Report following a request for further information, negotiations or consultation

REF NO:	P/153/21/RES
LOCATION:	Land South of Summer Lane and West of Pagham Road Pagham
PROPOSAL:	Approval of reserved matters (appearance, layout, landscaping and scale) following outline planning Permission P/140/16/OUT for the erection of 350 No. dwellings, together with public open space, play space, drainage, parking and associated infrastructure, landscape, ancillary and site preparation works, with access off Pagham Road. This site may affect a Public Right of Way.

Recommendation Report for Approval of Reserved Matters Following Outline Approval

Proposed View F from Drawing 21.129.109 Showing Framed View of St Thomas à Becket Church

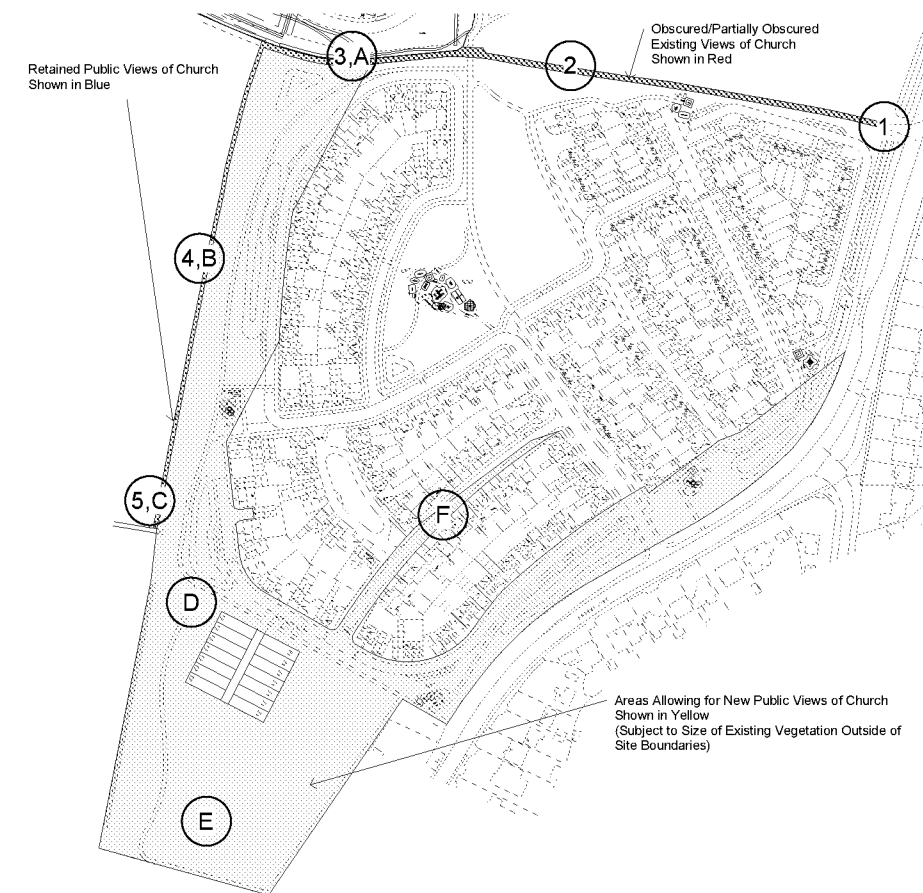
This application was presented to the Planning Committee on 13 December 2023. Members resolved to defer the application in order to secure clarification as to the height of the proposed dwellings and the impact this would have on the setting of St Thomas a Becket Church.

Officers understood that the concerns related to the height of the dwellings and the impact this would have on views, specifically from the PROW, towards St Thomas a Becket Church. Therefore, the application is unchanged, however further informative material has been provided by the applicant in order to visually demonstrate the height of the dwellings and the impact the development would have on views of the church.

The ridge height of the two storey dwellings within the southern parcel measure between 8.4m and 9m with an eaves height of 4.7m and 5.2m. The ridge height of the one and half storey dwellings, which are located adjacent to Pagham Road to the southeast, measure between 6.5m and 8m with an eaves height of between 2.45 and 2.9m.
